Subject: DEVIATION REVIEW AND DECISION FORM

**DEVIATION REVIEW
 AND DECISION FORM**

Subdivision or Project Name:
 PAINT BRUSH HILLS FILING 13E
 (Intersection Criteria and Tangent Length)

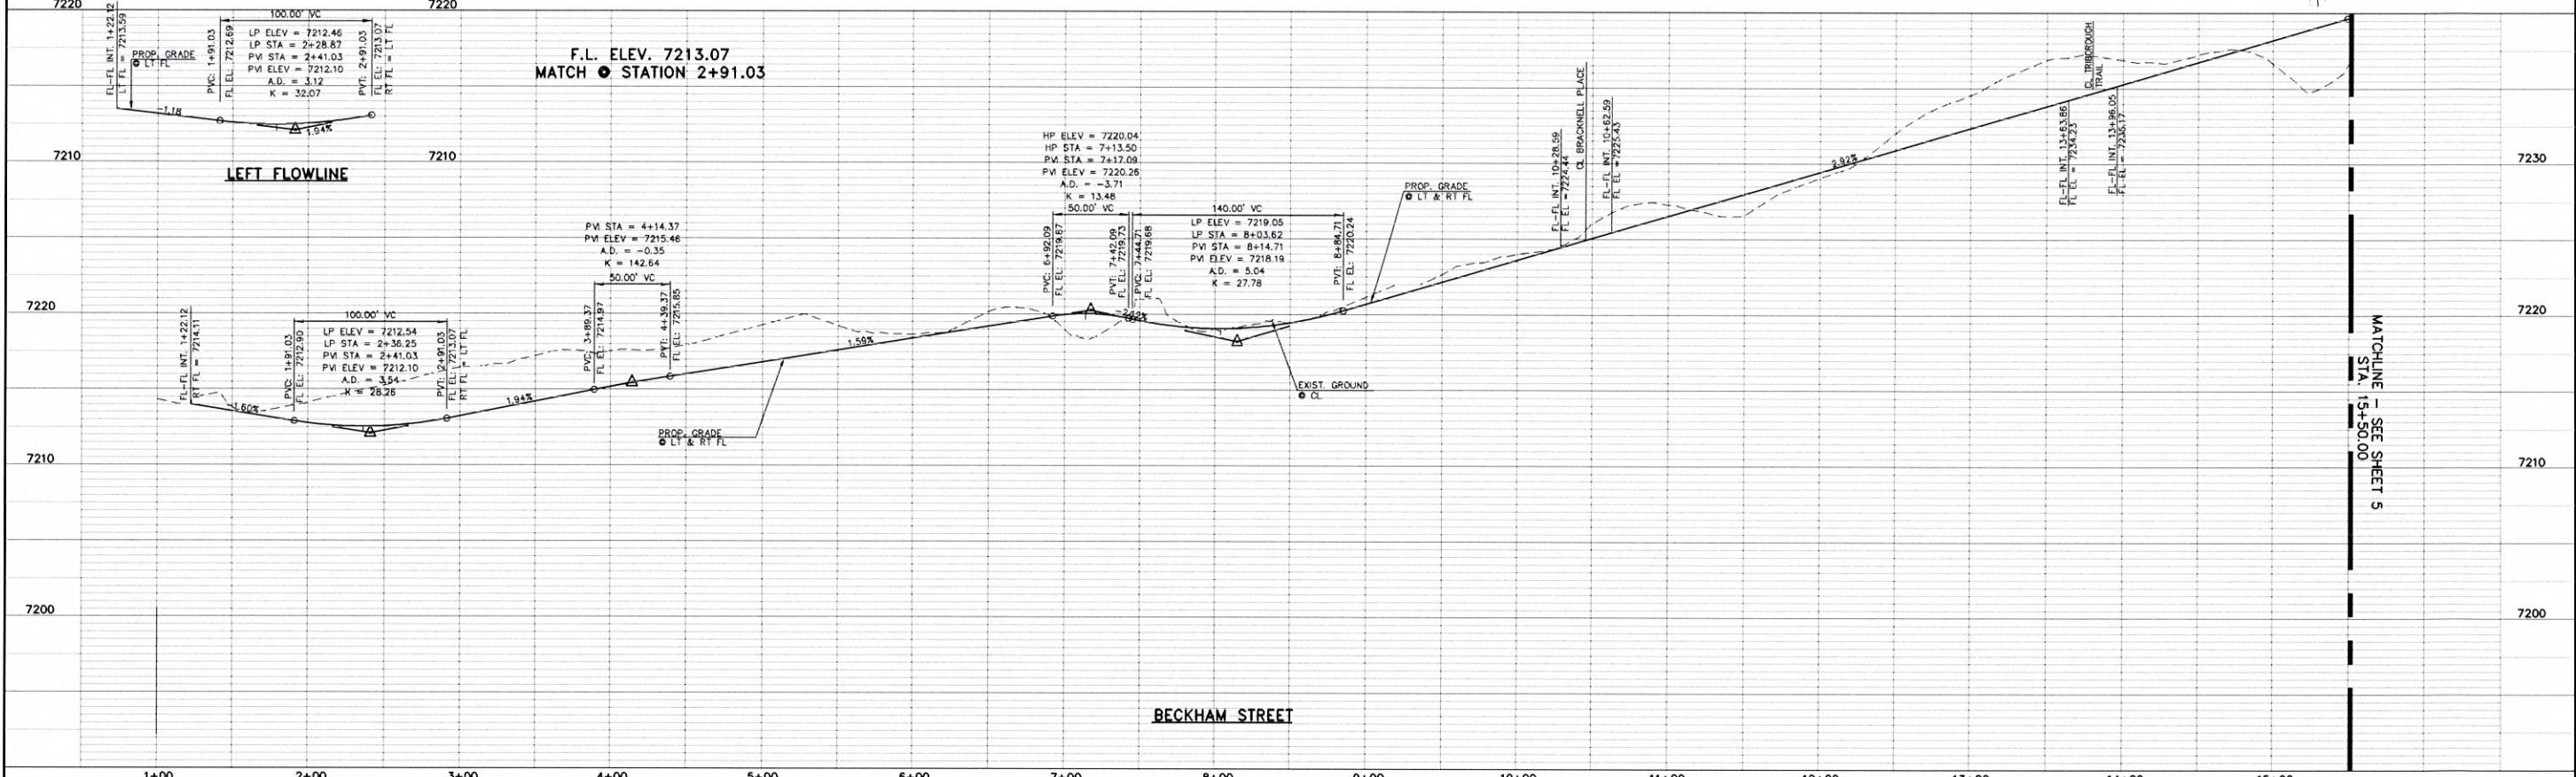
Review 1: Tangent length does not meet the min. 200' per ECM 2.3.3.F.3. Revise or submit a deviation for the county engineers' consideration.
Review 2: Unresolved.

Proposed Nature and Extent of Deviation: This proposed deviation includes two combined deviation requests: one for intersection spacing and the other for CL tangent length. These deviations are combined in one request due to the nature and history of the original proposed subdivision as previously approved Final Plat (Paint Brush Hills Filing 13). Paint Brush Hills Filing 13E is the fifth and last phase within the County's phasing program for the original Filing 13 Final Plat. This Final Plat was approved by the BOCC back in 2006 with many years of requested extension letters and continued phased Final Plat recordations over the past decade. The proposed Filing 13E subdivision matches the original Final Plat, which at that time did not request any deviations from ECM criteria. The extent of the deviations are as follows: Distance from the existing intersection of Londonderry Dr. and Towner Ave. to the intersection of Londonderry Dr. and the proposed Triborough Trail equals 302 LF where the minimum distance equals 330 LF. Broken back curves within Triborough Trail (Sta. 14+50), Beckham St. (Sta. 7+00 and 15+50) and Keating Dr. (1+50) have CL tangents less than 200 LF. (See attached Exhibit)

Comparison of Proposed Deviation to ECM Standard: Per ECM standard Table 2-7: Urban non-res. collector to local intersection spacing minimum equals 330 LF with the proposed intersection spacing equals 302 LF. Per ECM standard 2.3.3.F.3 minimum tangent length between broken back curves on local roads equal 200 LF. Triborough Trail tangent length through Sta. 14+50 equals 64.89 LF, Beckham St. tangent through sta. 7+00 equals 101.68 LF and sta. 15+50 equals 132.69 LF, Keating Dr. through sta. 1+50 equals 76.66 LF.

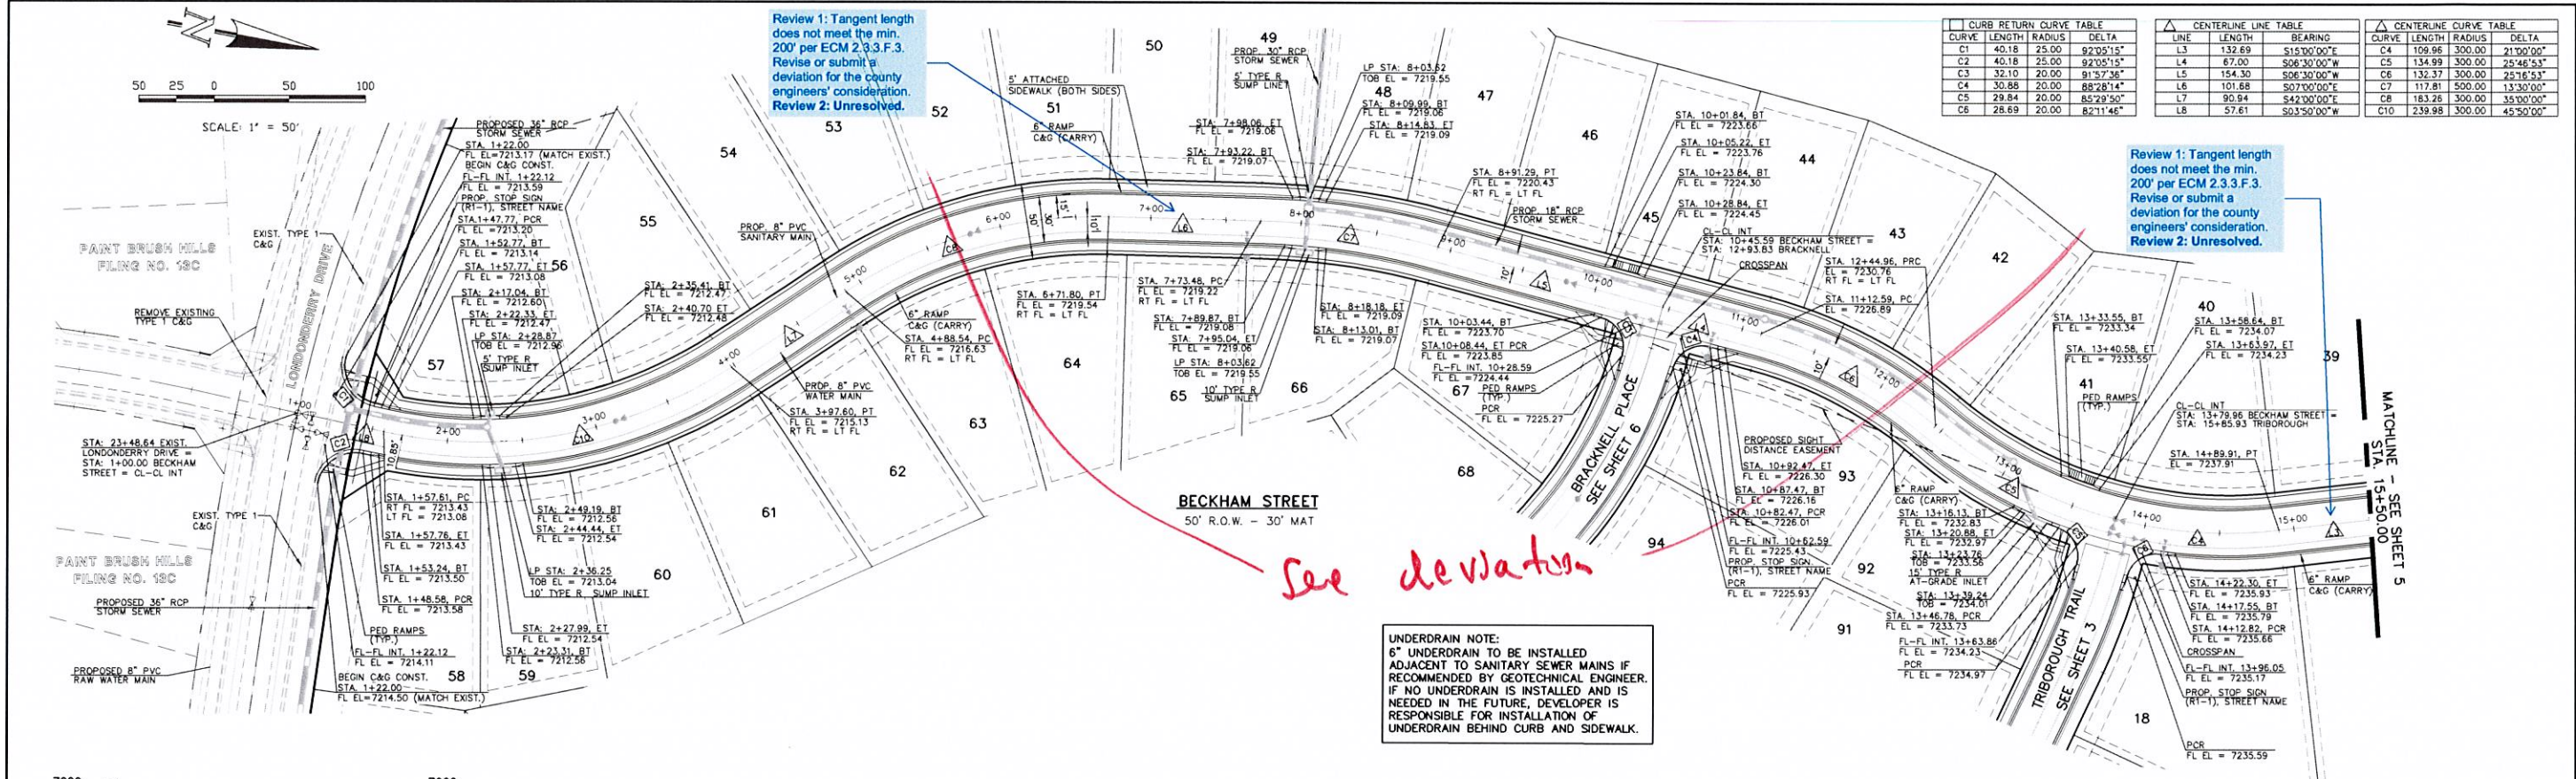
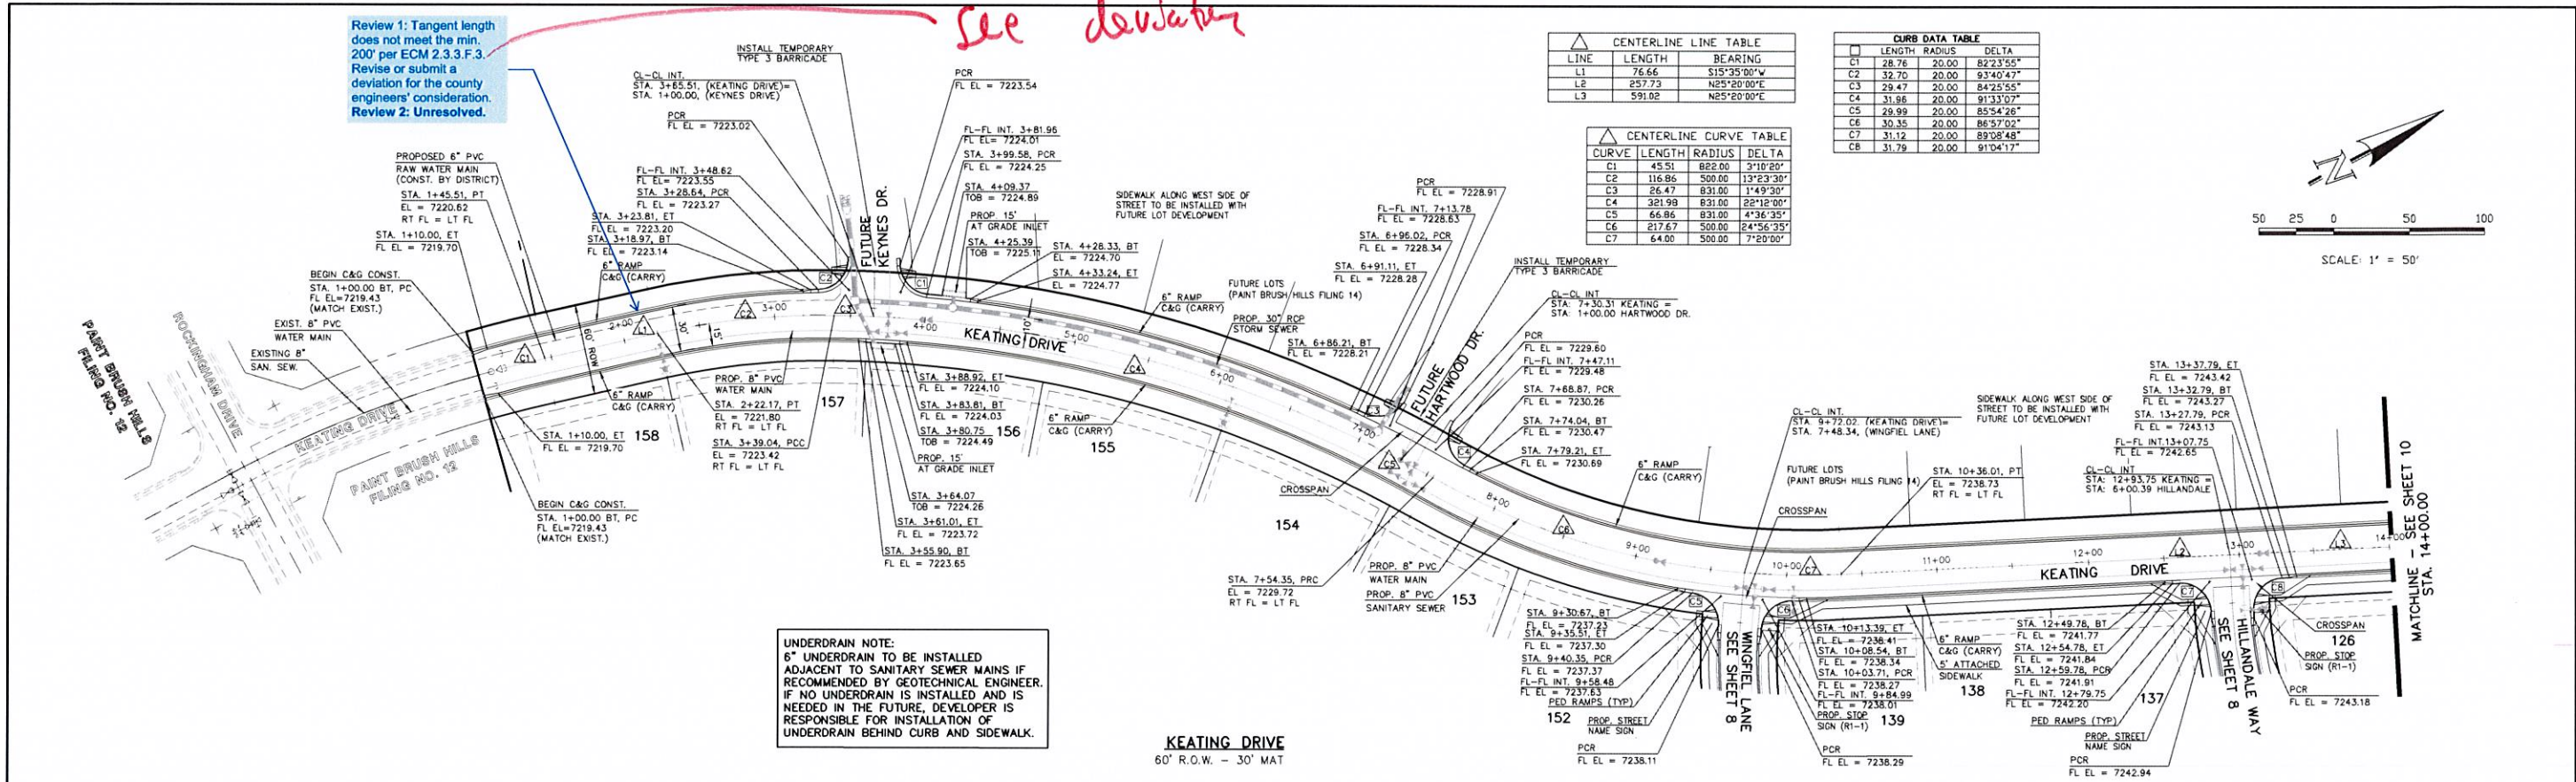
Review 1: Tangent length does not meet the min. 200' per ECM 2.3.3.F.3. Revise or submit a deviation for the county engineers' consideration.
Review 2: Unresolved.
